**Planning Department
Transportation Development Services**

**Re: McDonalds, 6300 San Mateo Blvd.
Traffic Circulation Layout**
Architect's Stamp dated 11-05-14 (E18-DO19C)

Based upon the information provided in your submittal received 11-07-14, the above referenced plan cannot be approved for Building Permit until the following comments are addressed:

**ACCESSIBLE PARKING SIGN DETAIL**  
 NOT TO SCALE

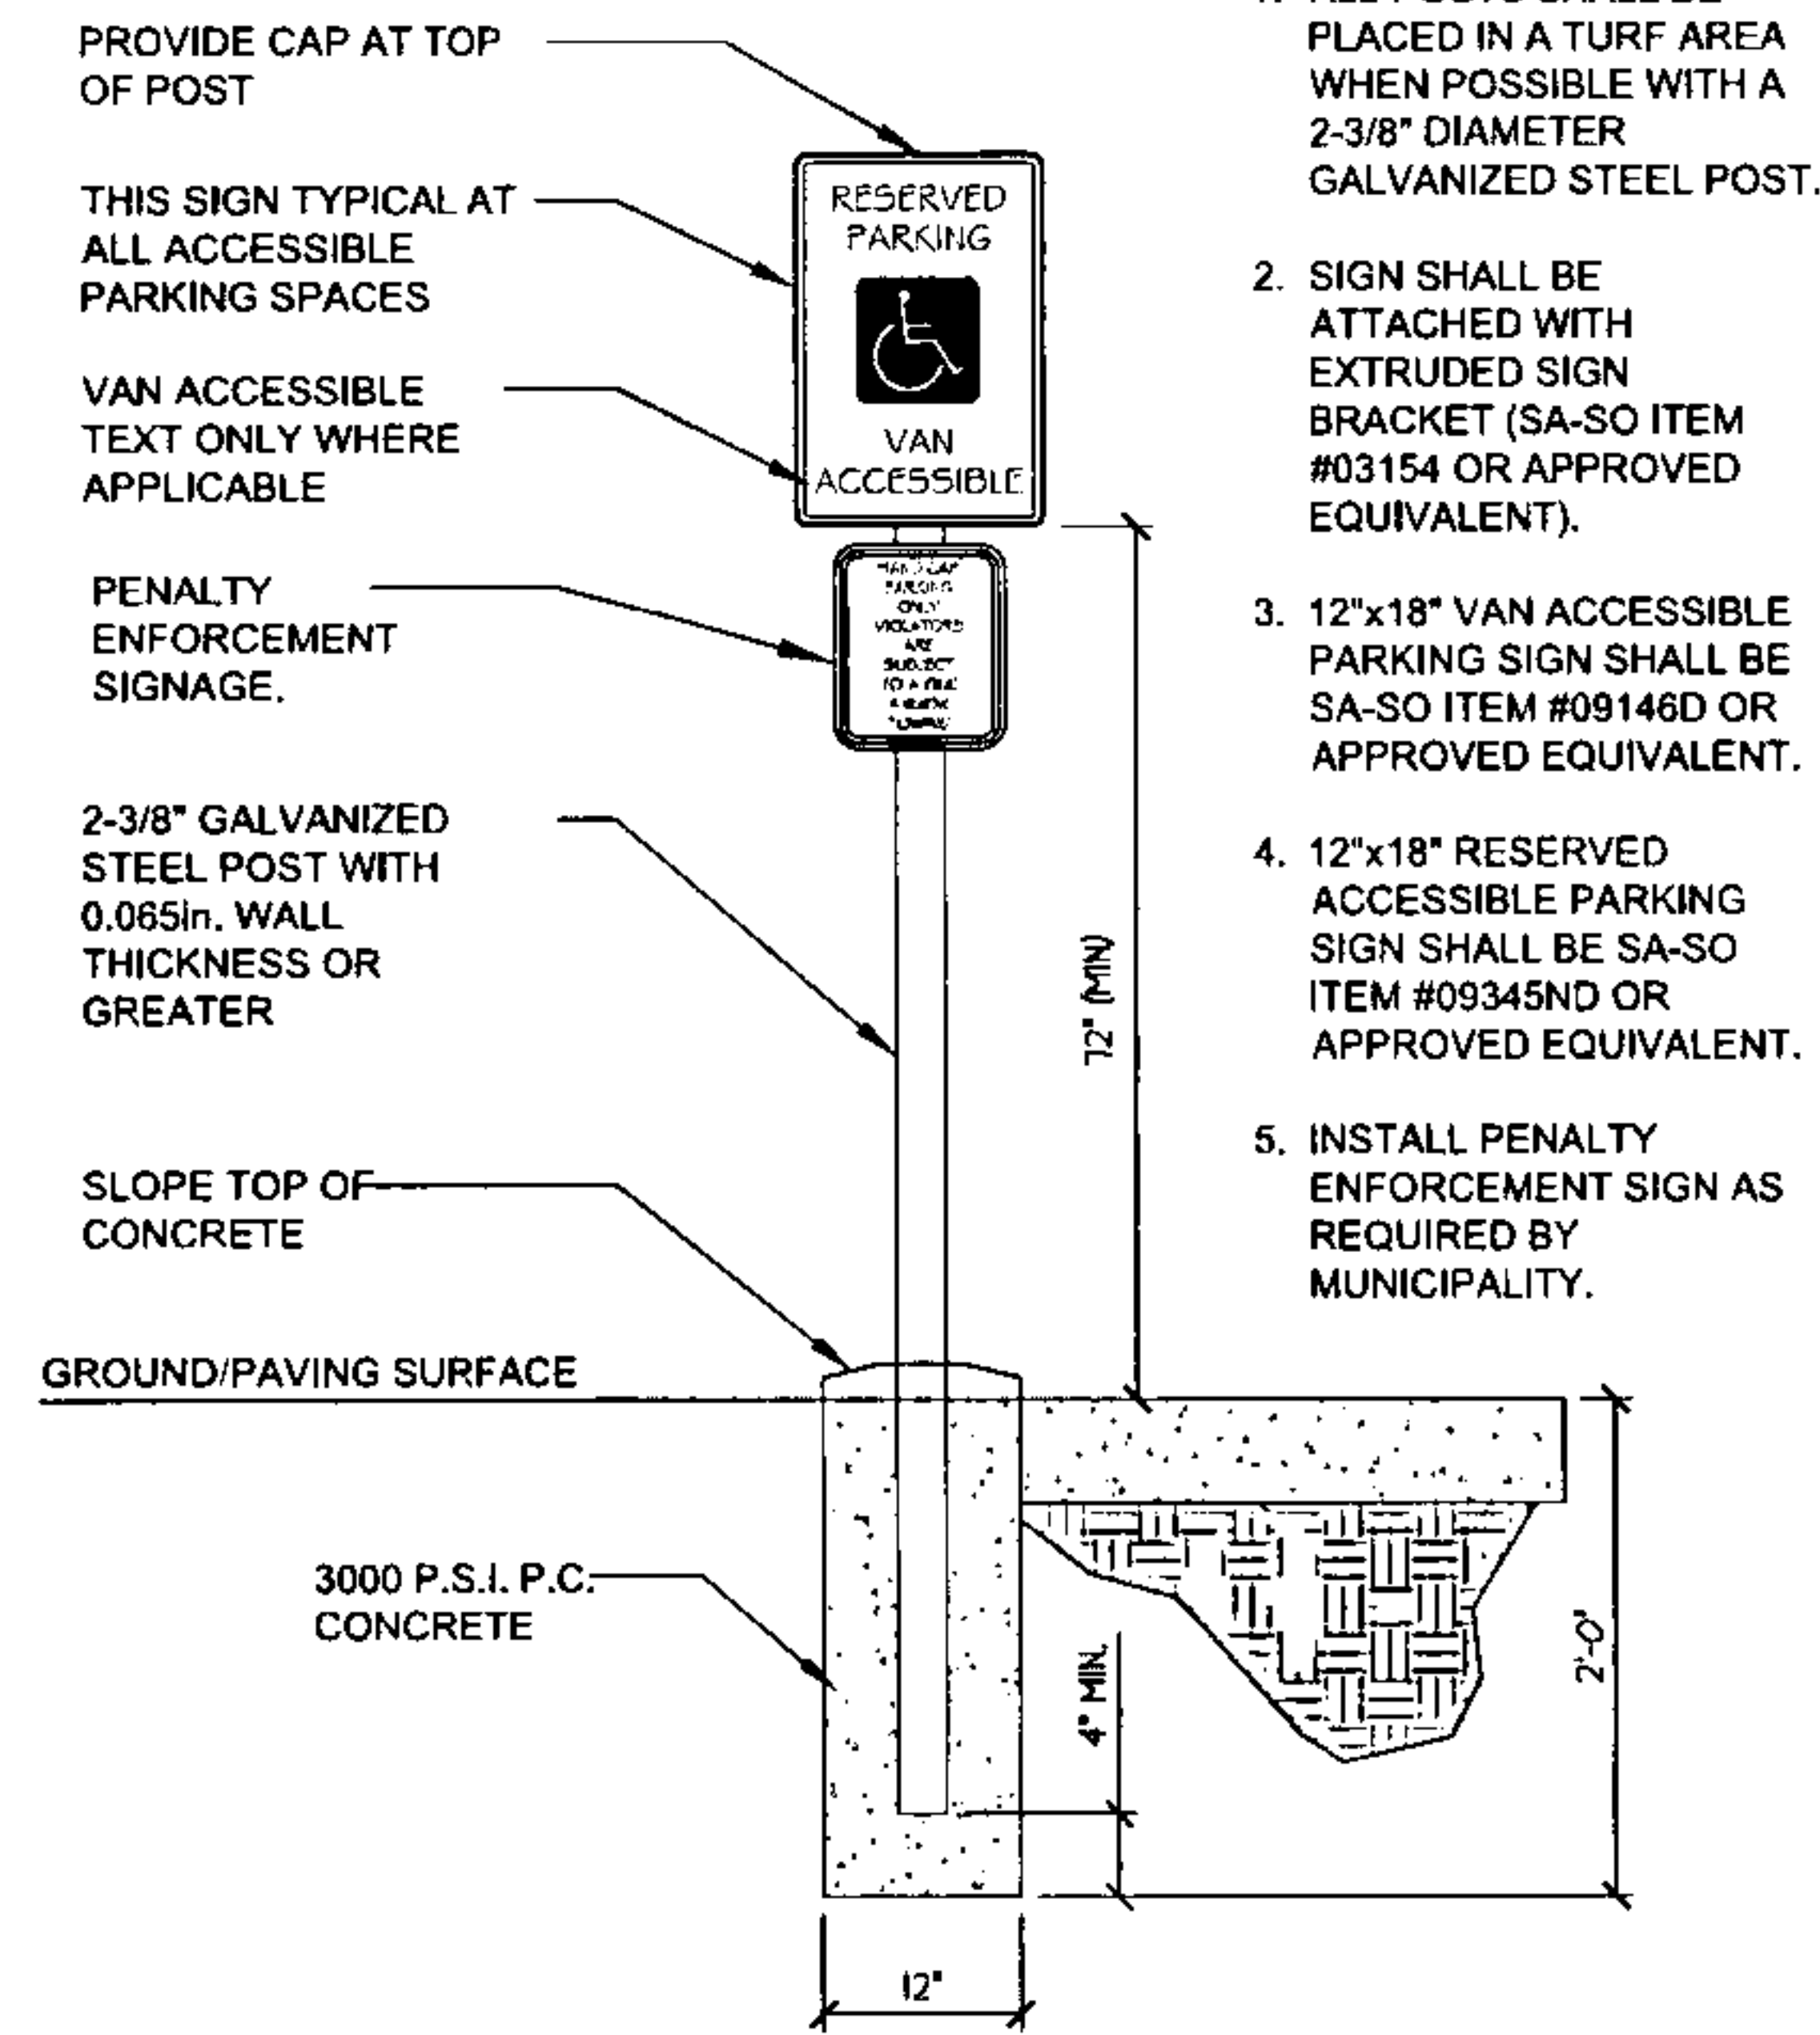
4. Include an ADA van accessible sign. This sign must have the required language per 66-7-352.4C NMSA 1978 **"Violators Are Subject to a Fine and/or Towing."** (Provide sign detail on Sheet C10.1 as called out by Keyed Note 7 on the plan sheet.)
